May 2, 1979

REF: 7-11 Bldg. at Gibson Boulevard and Miles Road

Re: 7-11 Stores

G MENAUL NEAR TRAMWAY N.E.

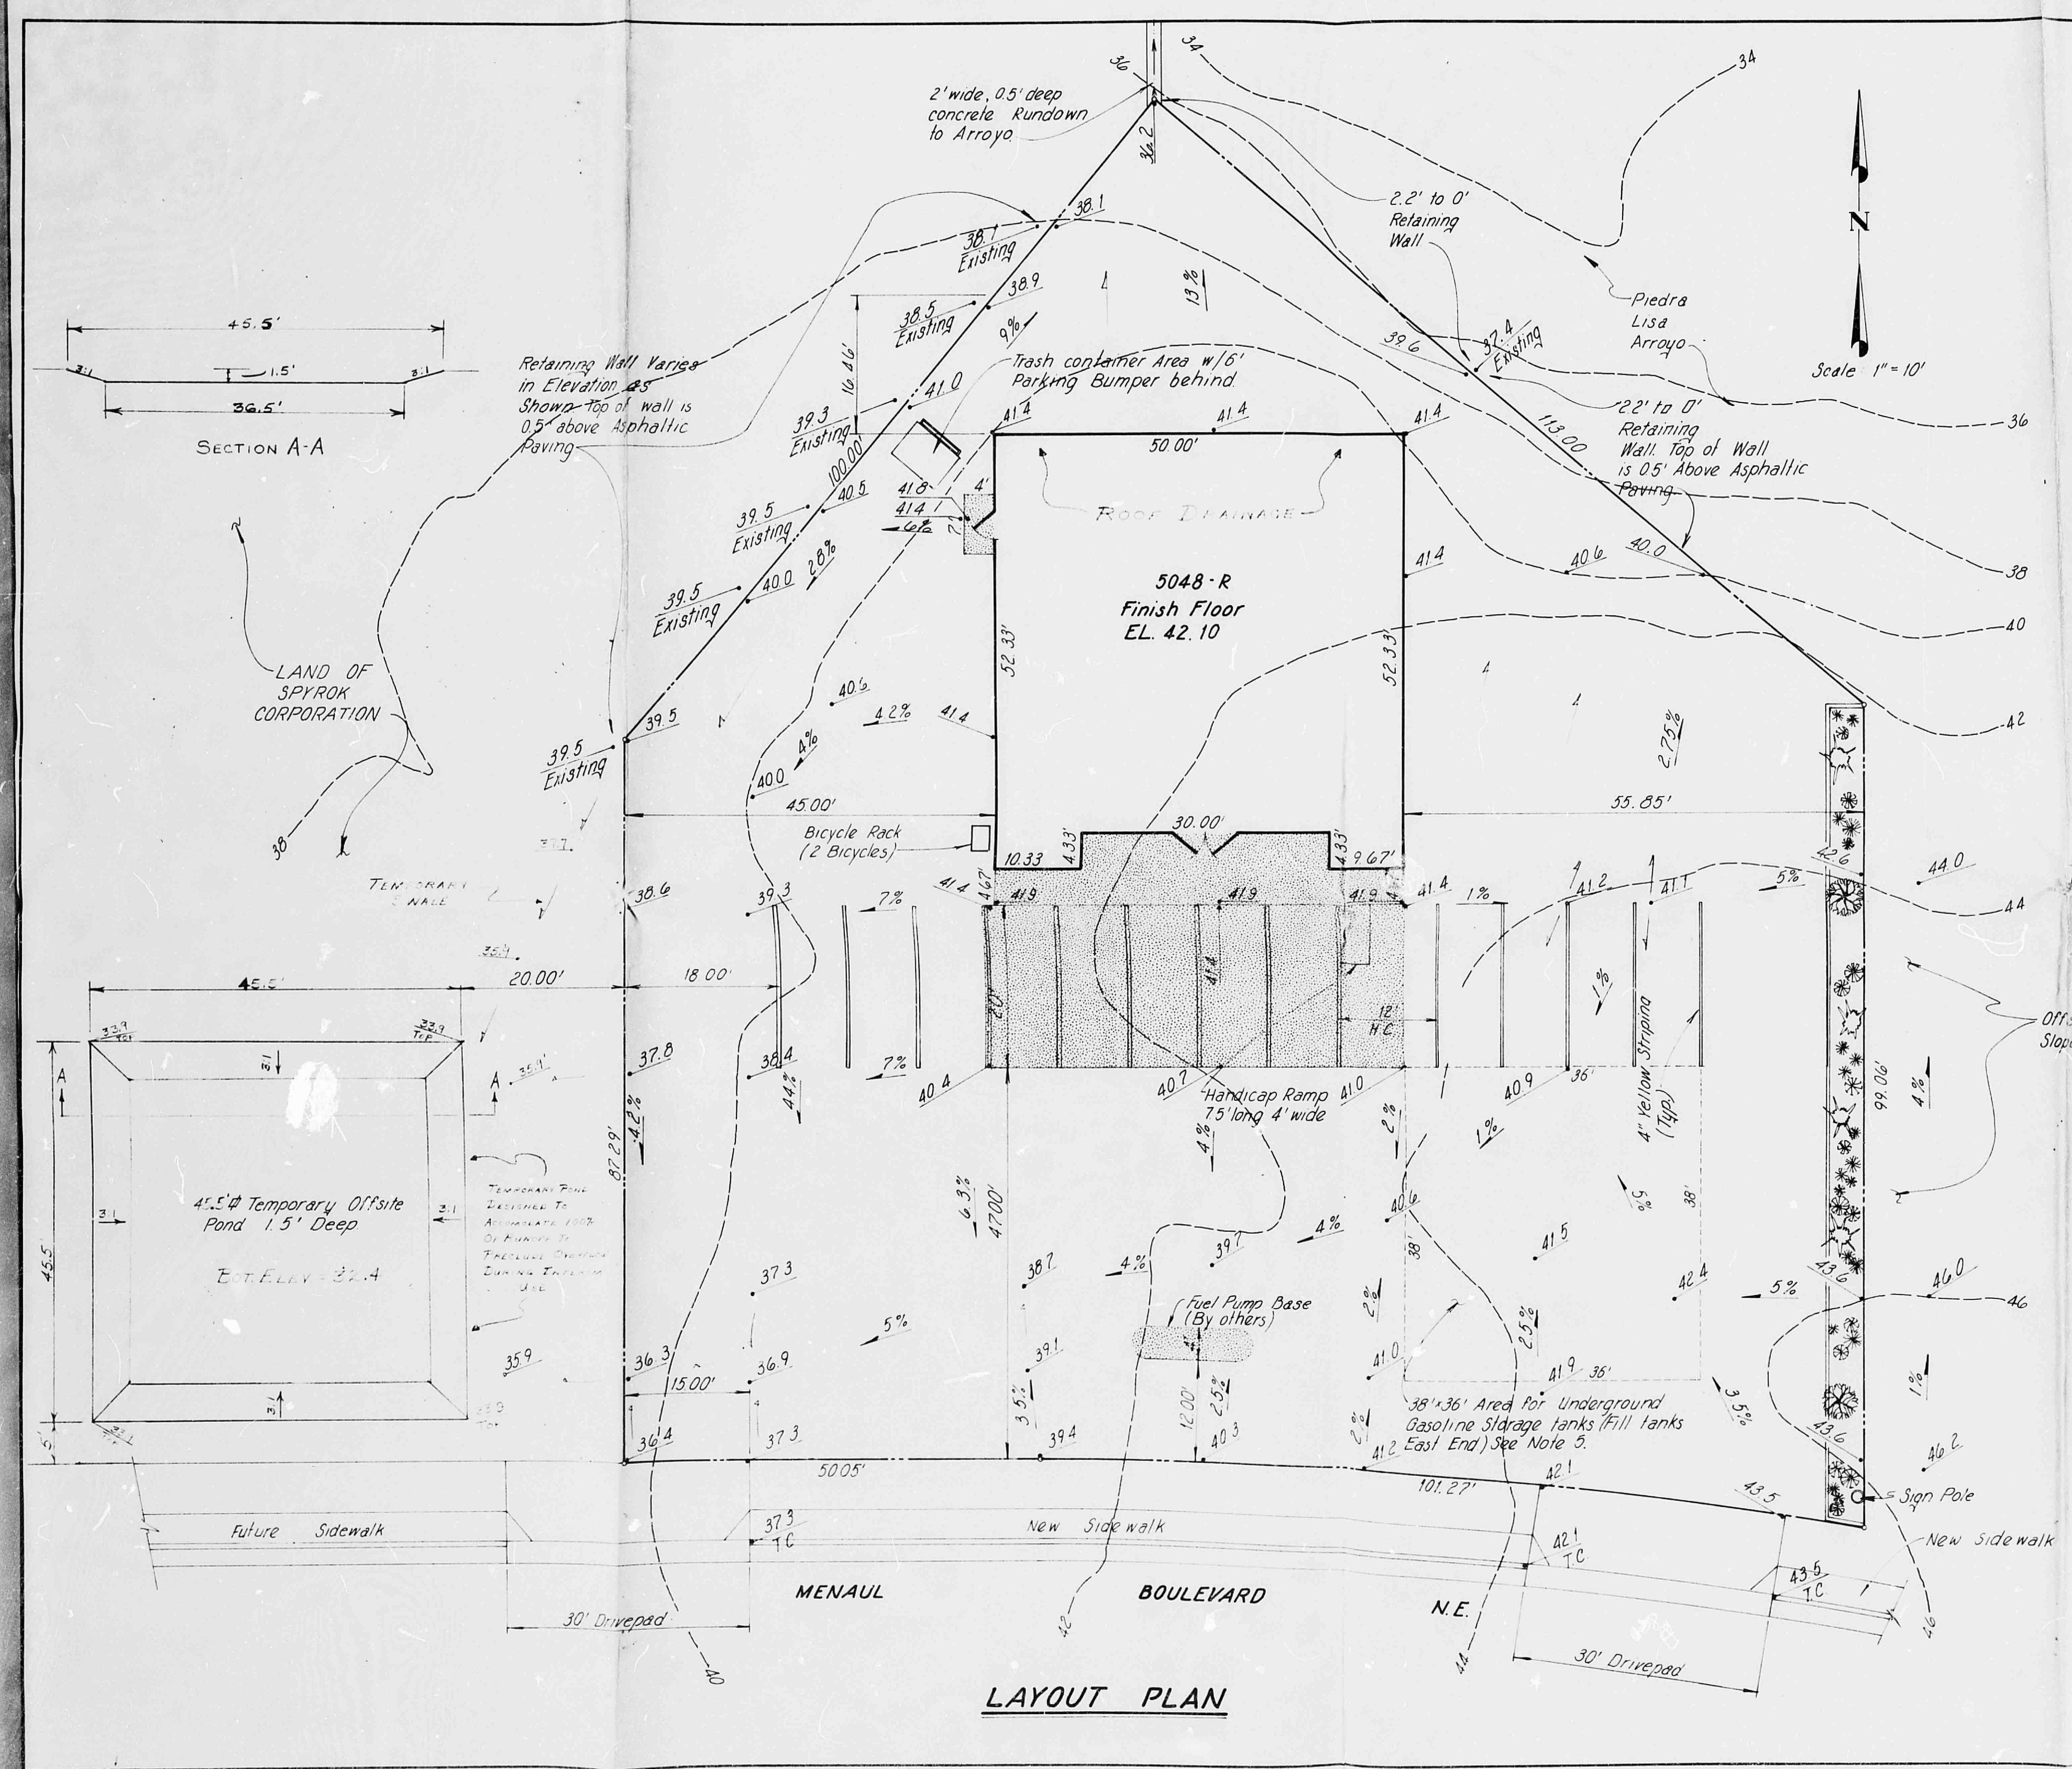
I have reviewed the site grading and drainage plans for the 7-11 Stores to be located at 10324 and 12801 Menaul Blvd. N.E. The provision of ponding on adjacent land is not acceptable if it is not accompanied by a dedication and restriction of the use of the land covered by the pond which must be recorded with the County and run with the property. Be also advised that a drainage plan must supply answers to the questions shown in the enclosed check list in detail. In particular the safety of the finished floor elevation of the proposed building against flooding must be established.
